Subject: Land at Bilsham Road Yapton - Y/15/22/DOC

Planning Application Reference: Y/15/22/DOC

Proposal: Approval of details reserved by condition imposed under Y/91/17/OUT relating to condition 25-Electric Vehicle Charging Strategy

Location: Land at Bilsham Road Yapton

DRG No.
C0033_THAK_001

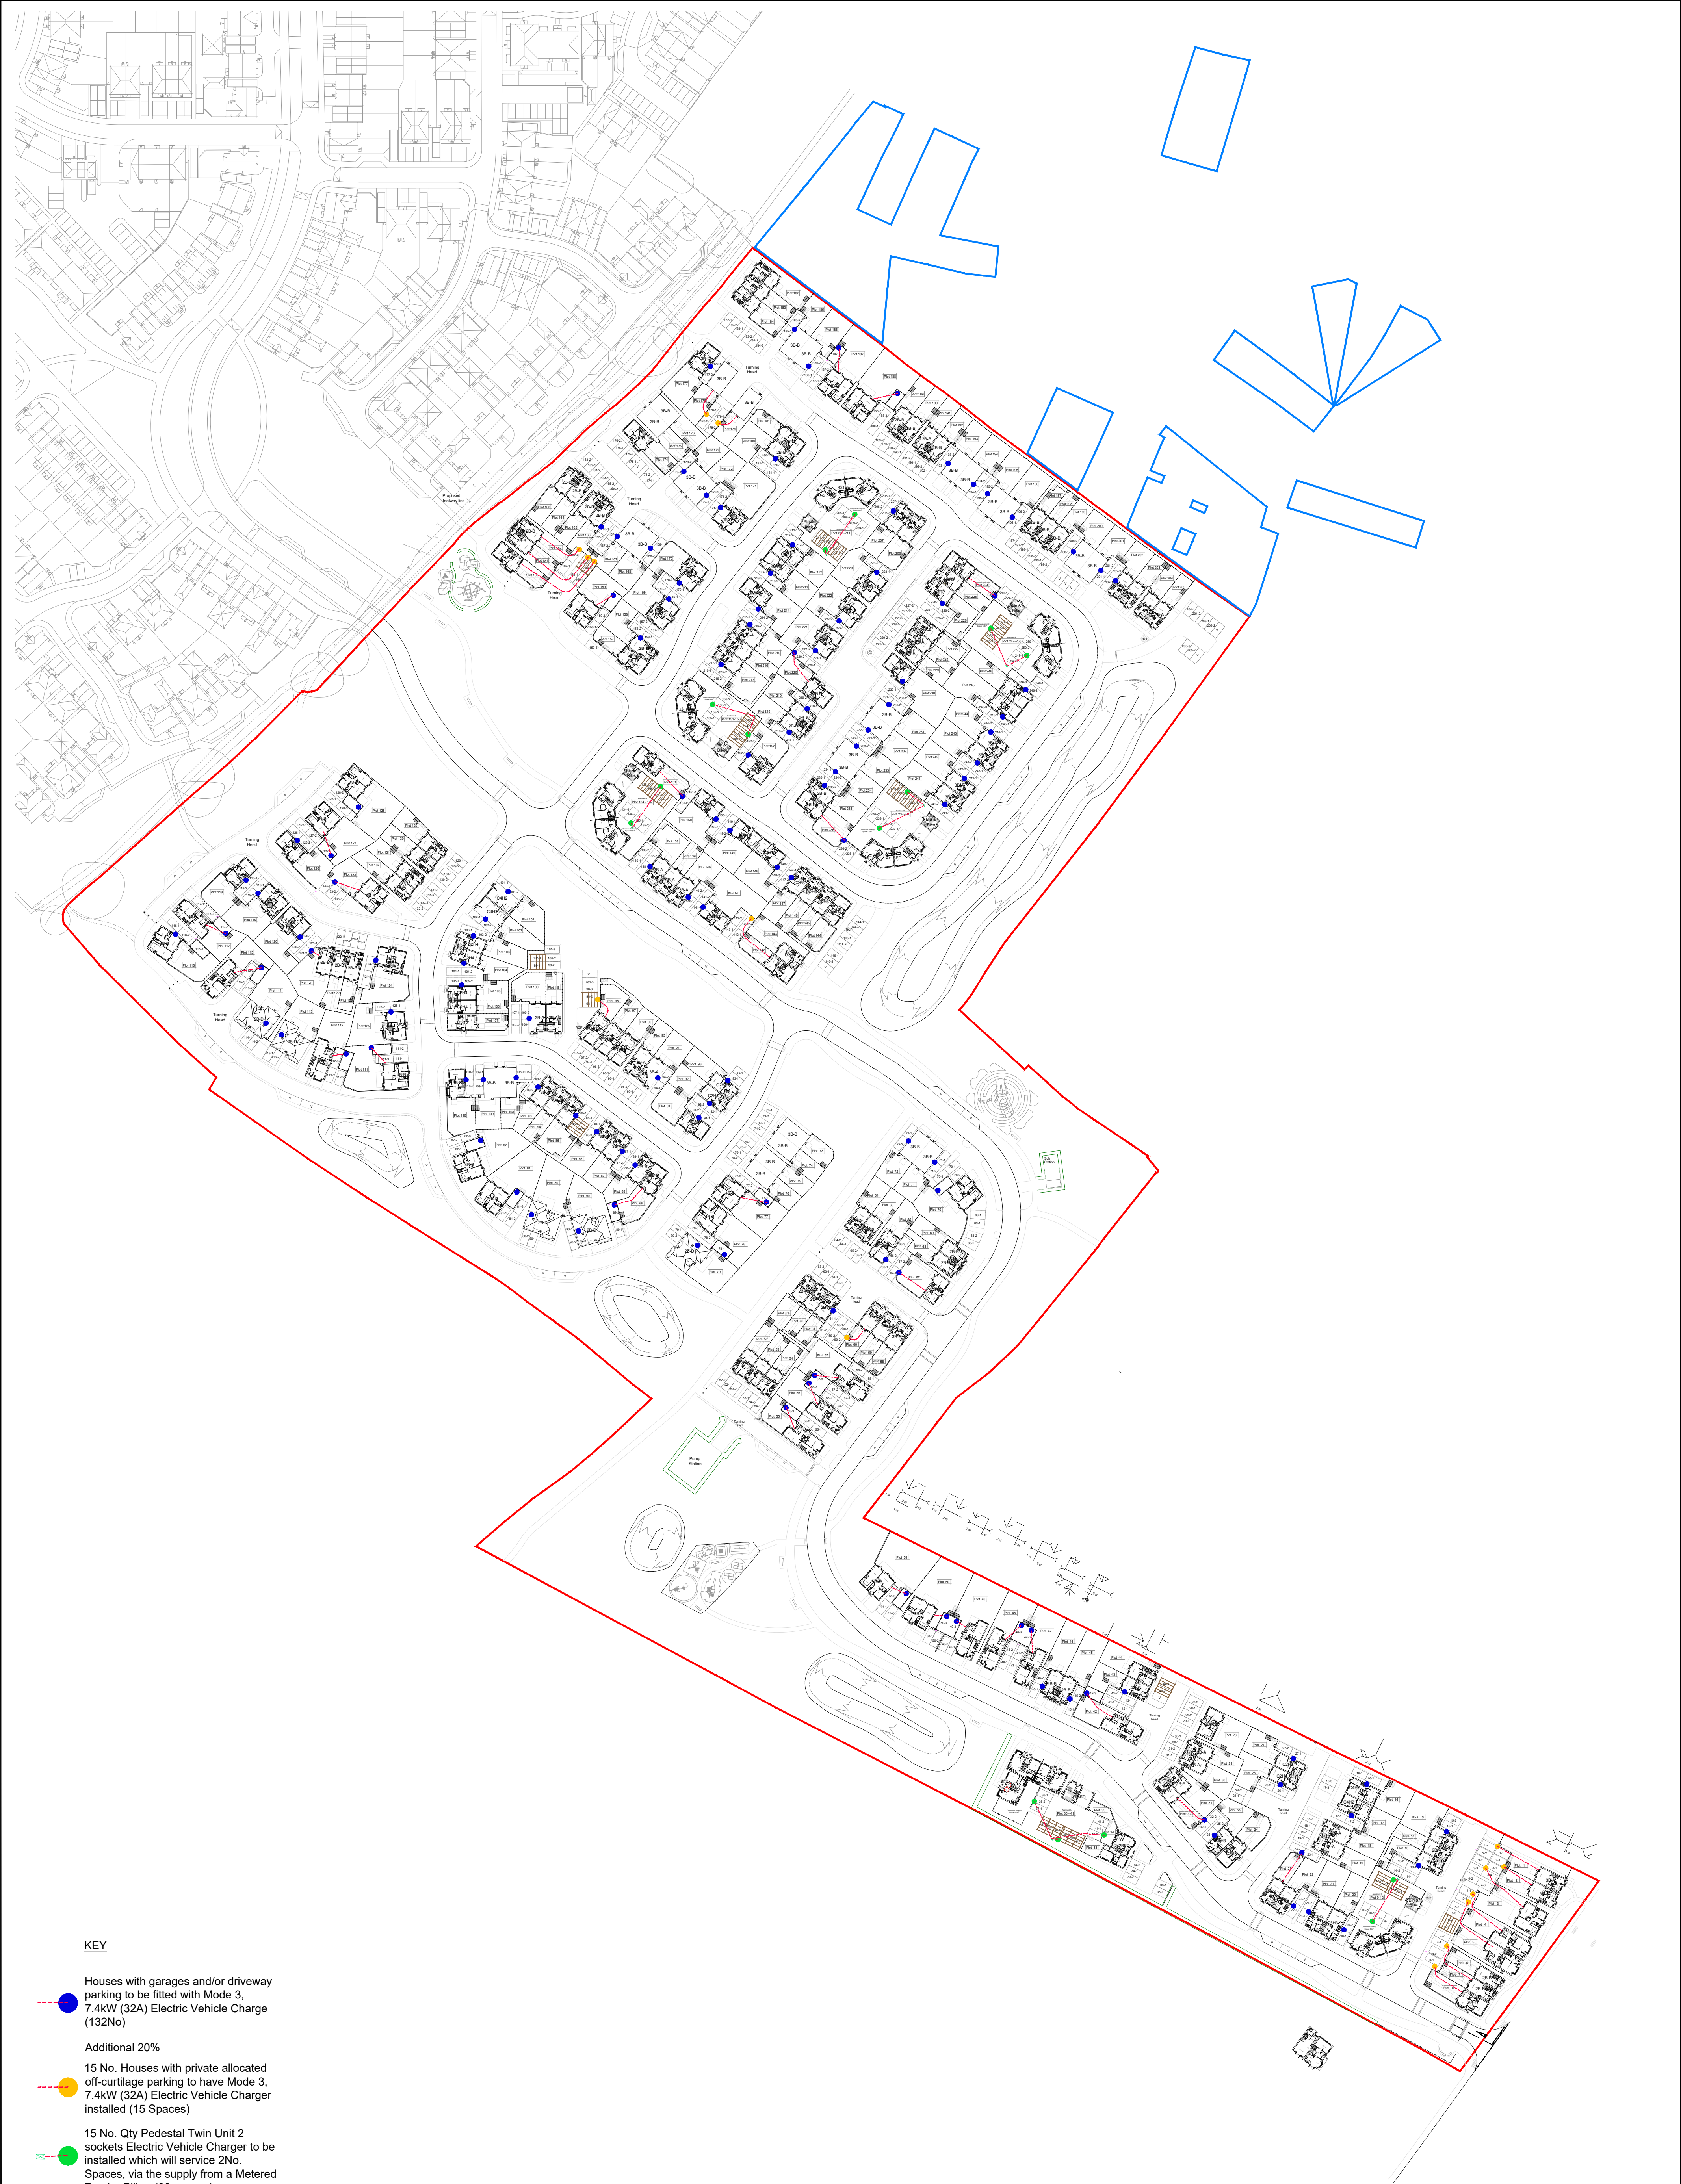
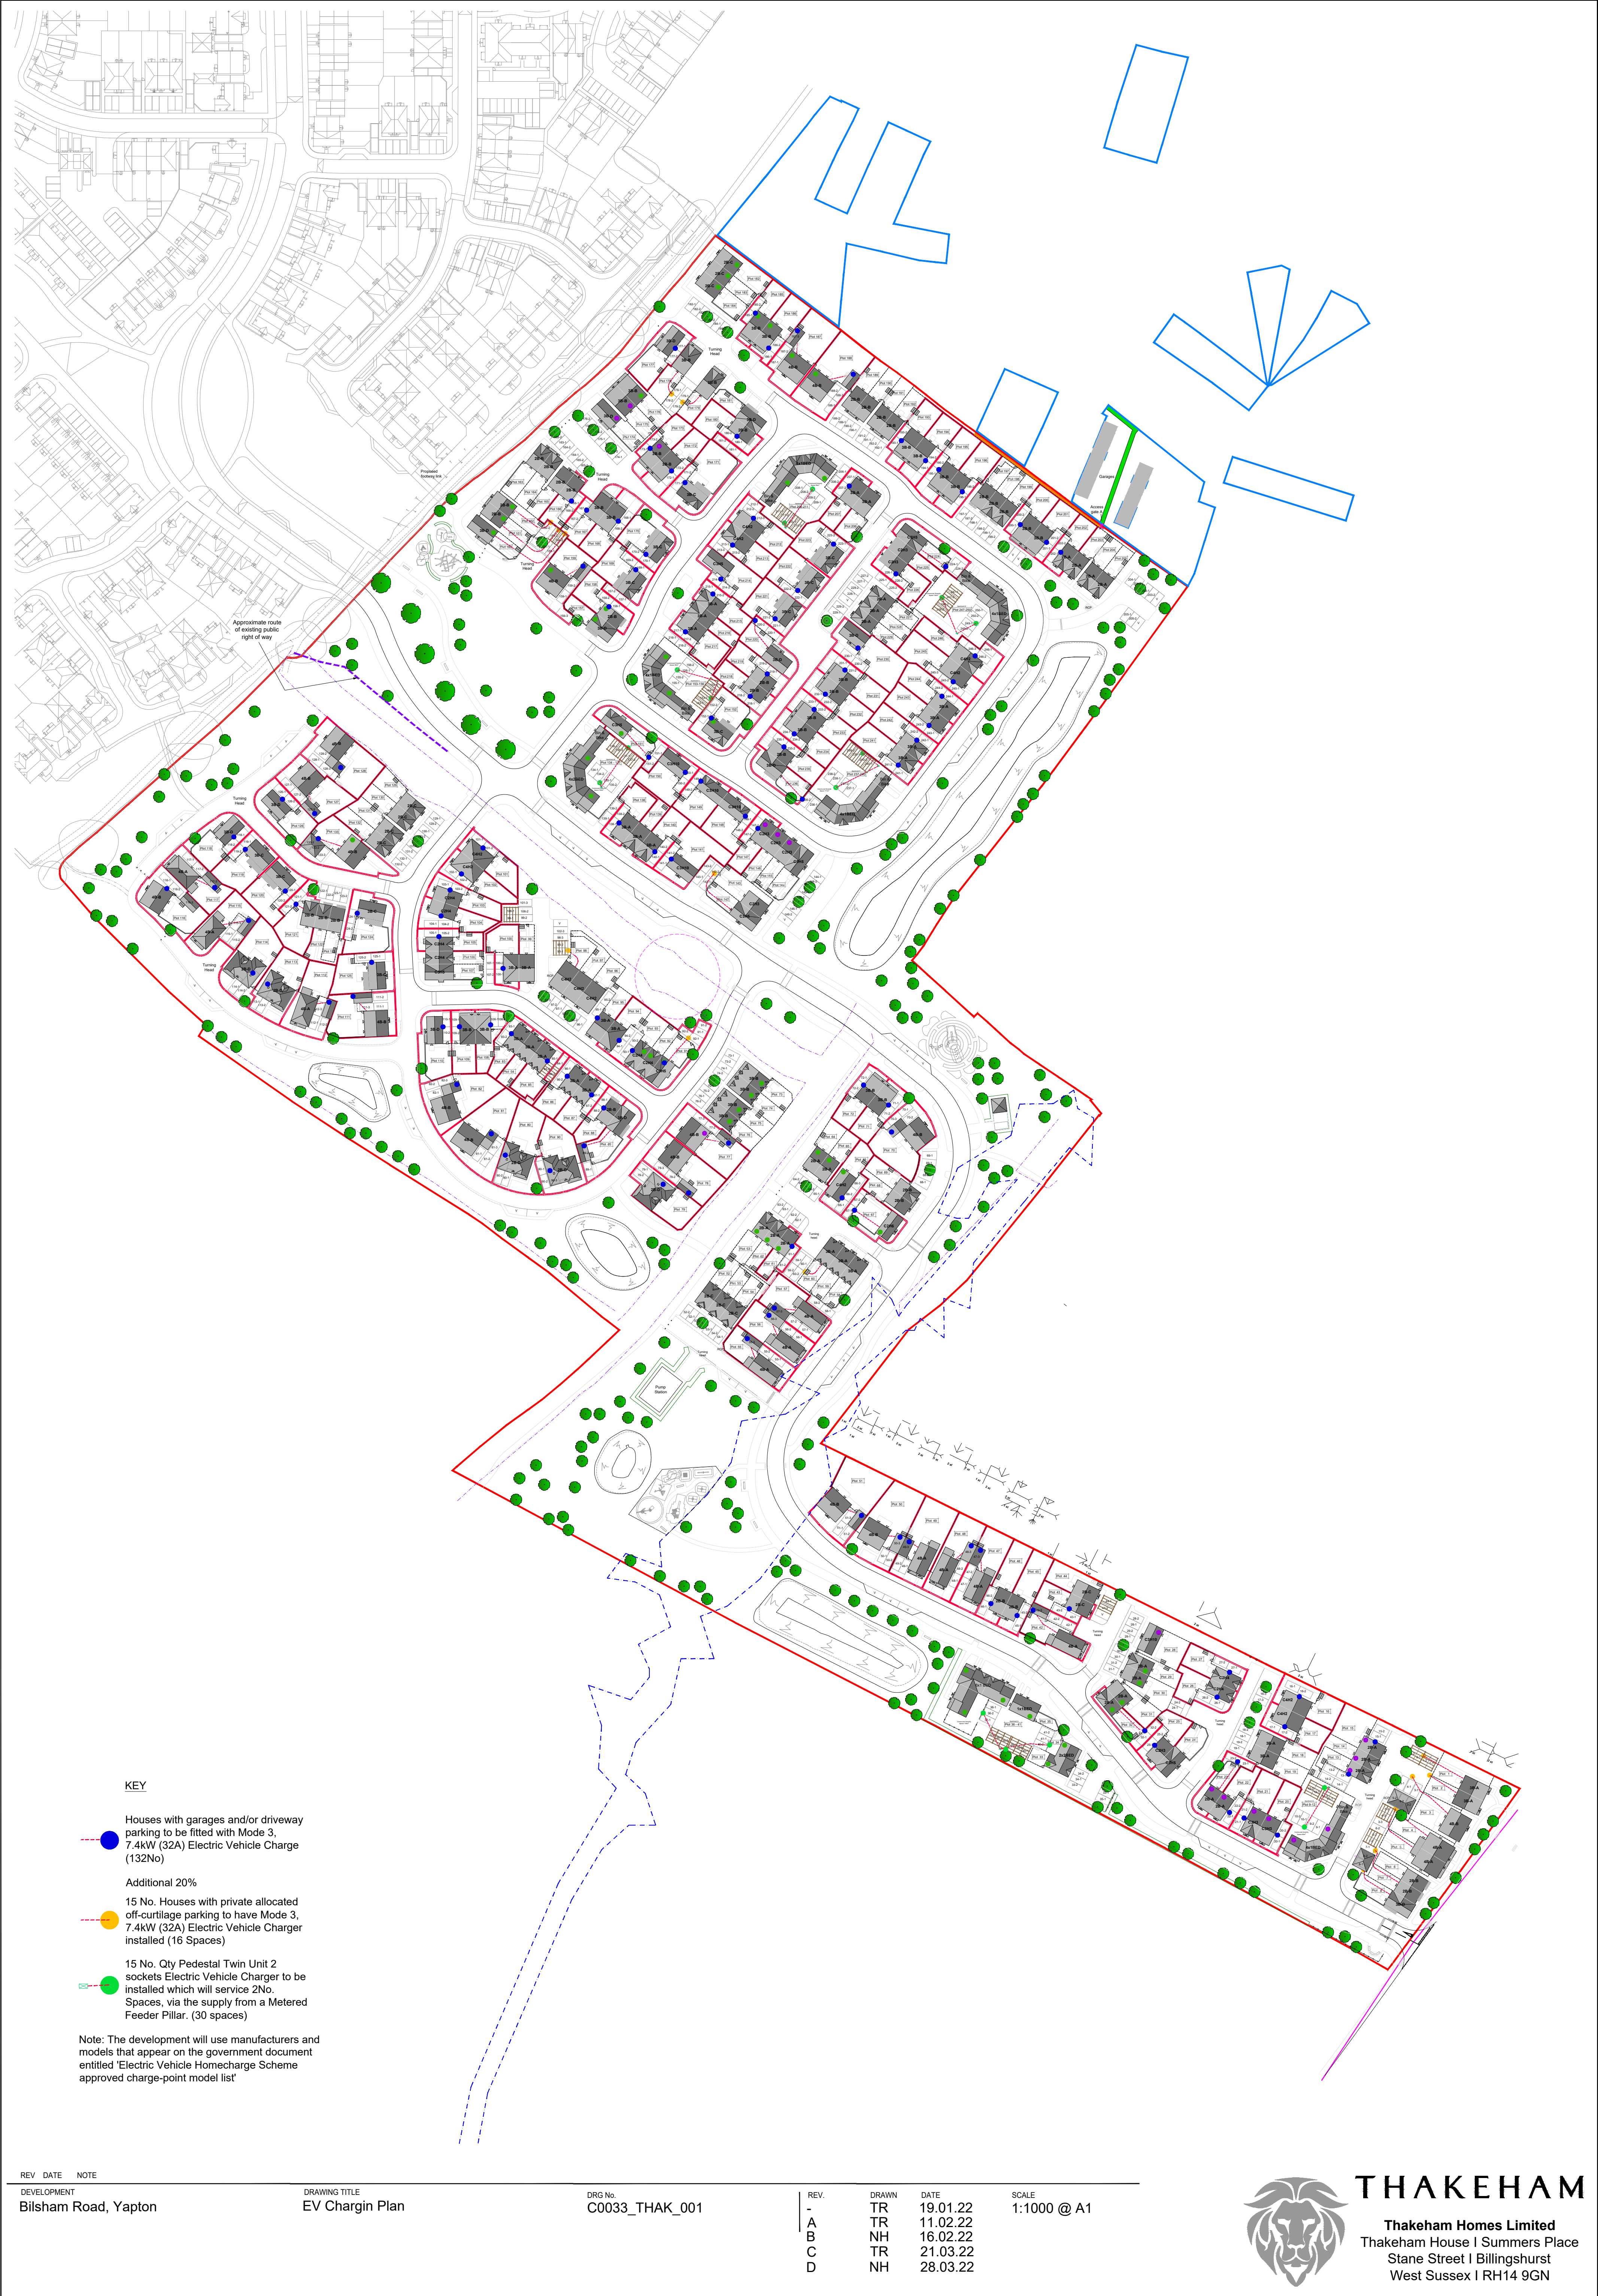
Having reviewed the document entitled 'EV Charging Plan C0033_THAK_001' I require further information. The requirement for electric vehicle charging points is dependent upon the number of associated parking spaces within the boundary of a dwelling.

I therefore request the applicant submit an amended EV Charging Plan which details the plot boundaries for each plot within the proposed development.

Furthermore, the applicant shall be required to provide full details of the manufacturer and model of the proposed electric vehicle charging points, and ensure that the specified manufacturer and model appear on the government document entitled 'Electric Vehicle Homecharge Scheme approved charge-point model list'.
